**TOWN AND COUNTRY PLANNING ACT 1990 (AS AMENDED) SECTION 96(a)
NON-MATERIAL AMENDMENT APPLICATION TO PLANNING PERMISSION REFERENCE:
6/2018/1519/MAJ
LAND NORTH OF CHEQUERSFIELD, WELWYN GARDEN CITY**

“Variation of Condition 17 of planning permission reference: 6/2018/1519/MAJ dated 11 December 2018 for erection of 30 residential units with associated vehicular access, associated ancillary and enabling works – namely to allow for the repositioning of Flat Block A and the replacement of x 3 balconies with x 3 Juliet balconies on Flat Block B at flats 13, 19 and 25.”

Dwg No: LSD209-01 K
 Rev H: Access updated to suit drawing 22573-08-020-01 Rev C.
 Rev J: Parking updated to suit drawing 10390-250 Rev P3.
 Rev K: Updated to suit new survey information.

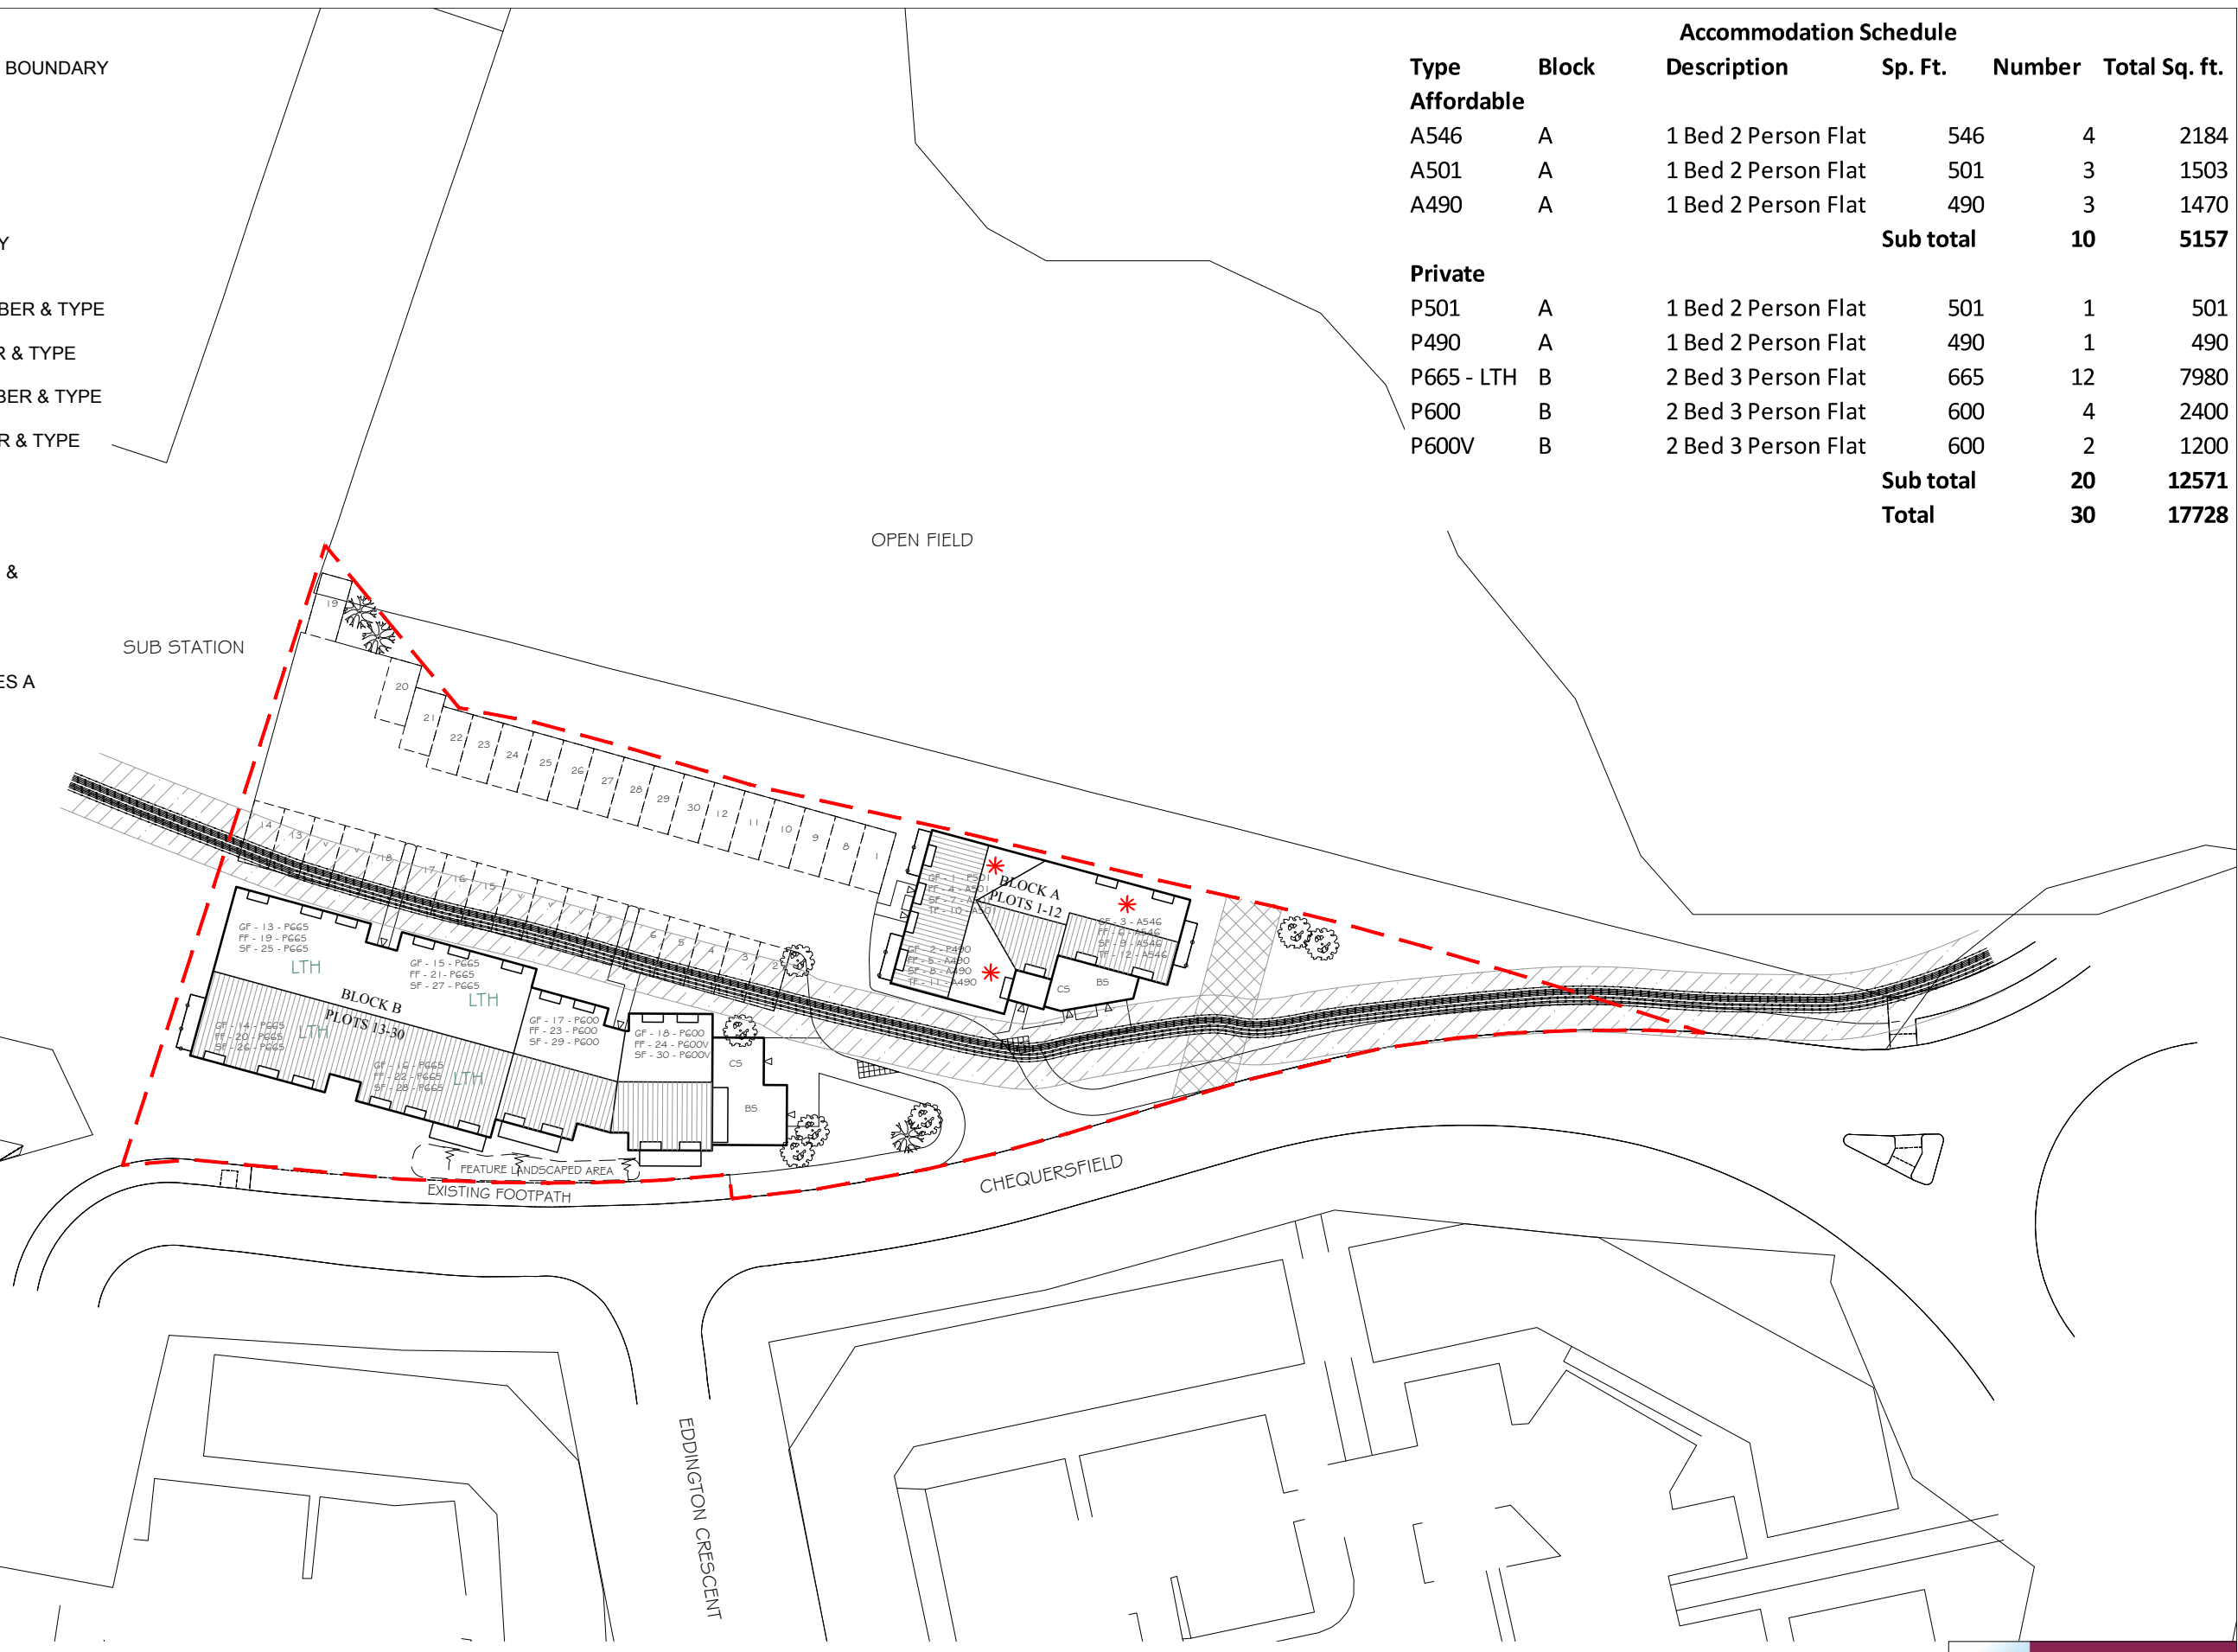
- As discussed earlier in this letter, further survey work has revealed that the HV cable is in a different position to that previously plotted. As such, Flat Block A is to be repositioned slightly further north and closer to boundary of the site. This is required in order to allow enough space between Flat Block A and the actual location of the HV cable and associated wayleave. This change would not result in any loss of amenity for residential residents.

LAND NORTH OF CHEQUERSFIELD, WELWYN GARDEN CITY - BLOCK B - FLOOR PLANS & ELEVATIONS (1:100 @ A1)

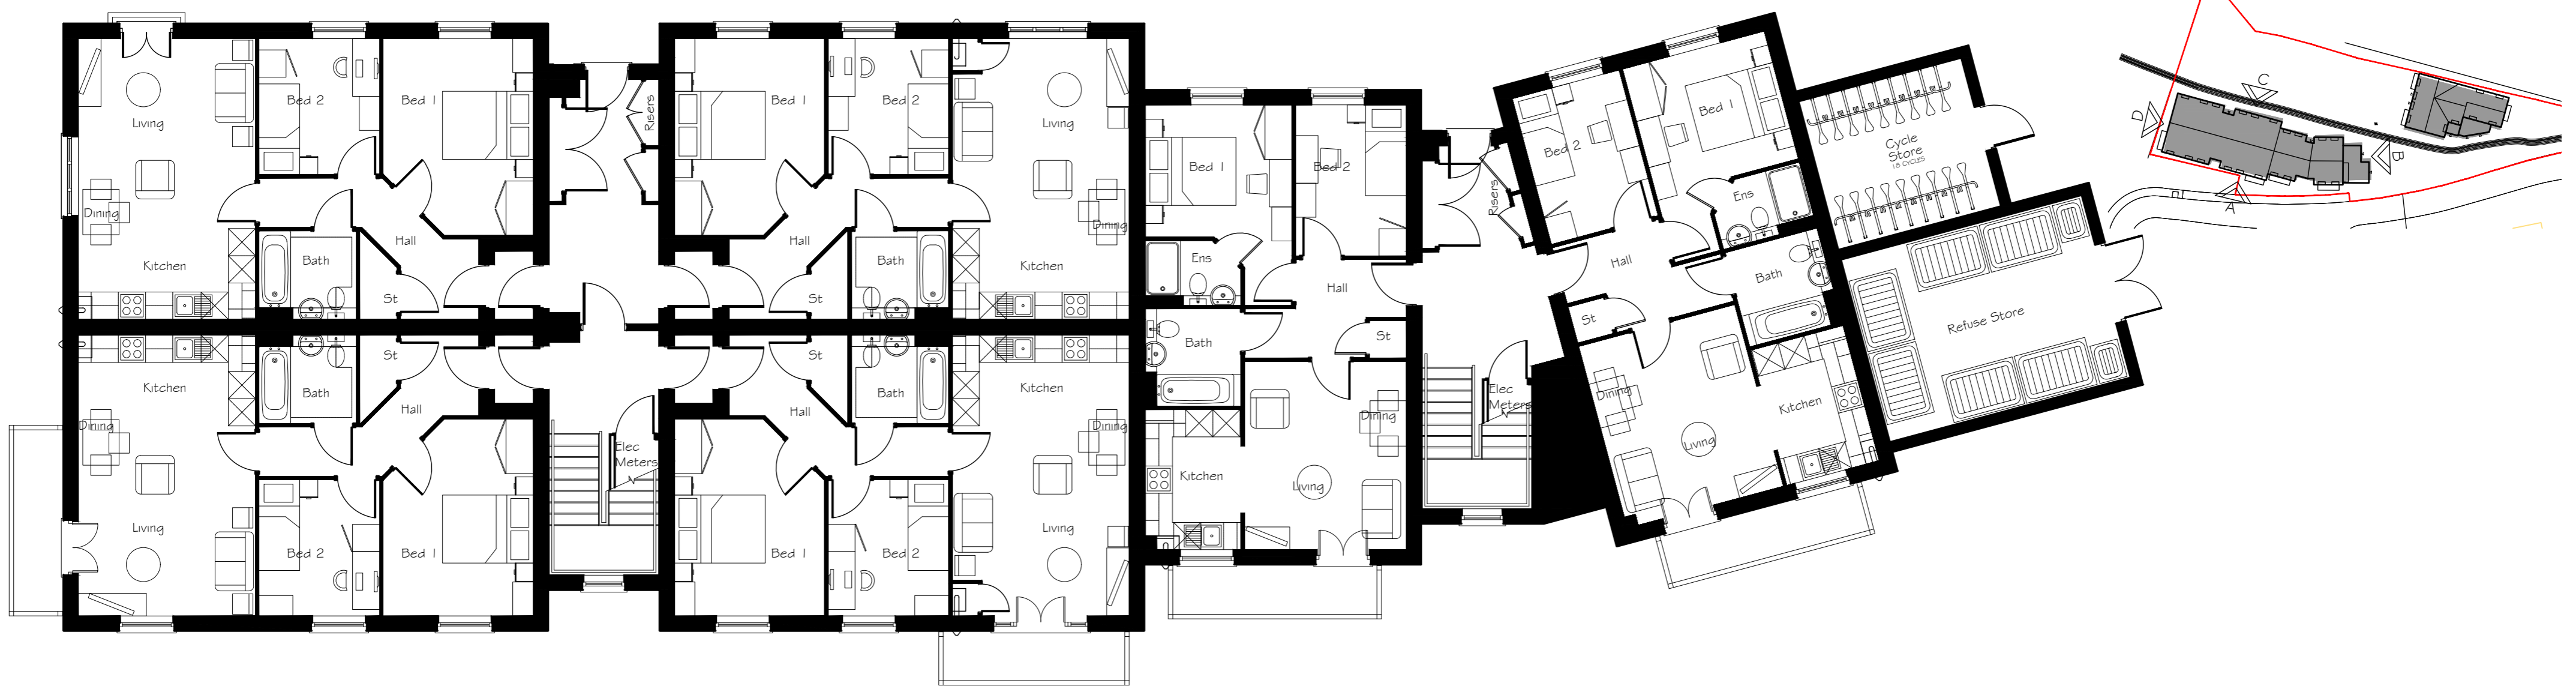
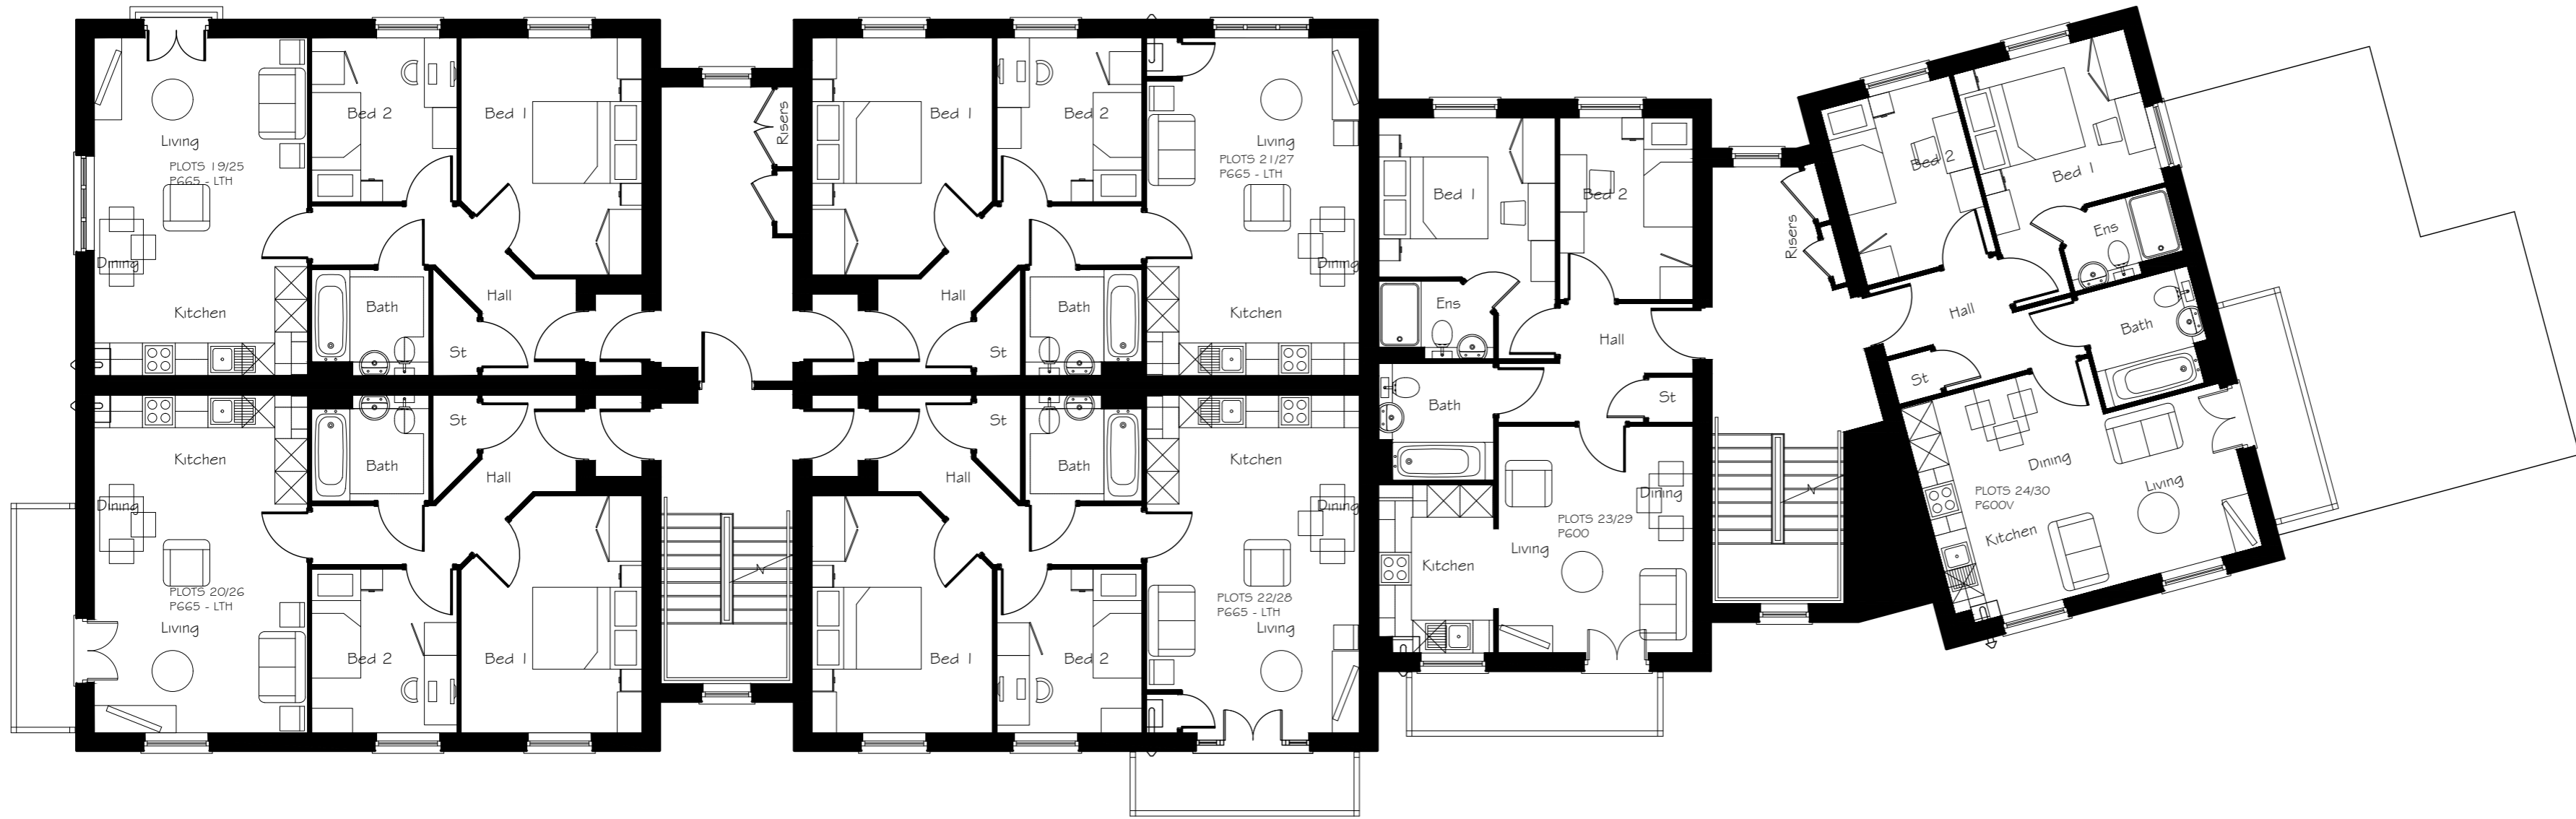
- The actual location of the HV cable and associated wayleave requires the replacement of x 3 balconies on Flat Block B with x 3 Juliet balconies at flats 13, 19 and 25. This change is required so that the above-mentioned balconies do not over-sail the wayleave associated with the HV cable. This change does not impact upon residential amenity.
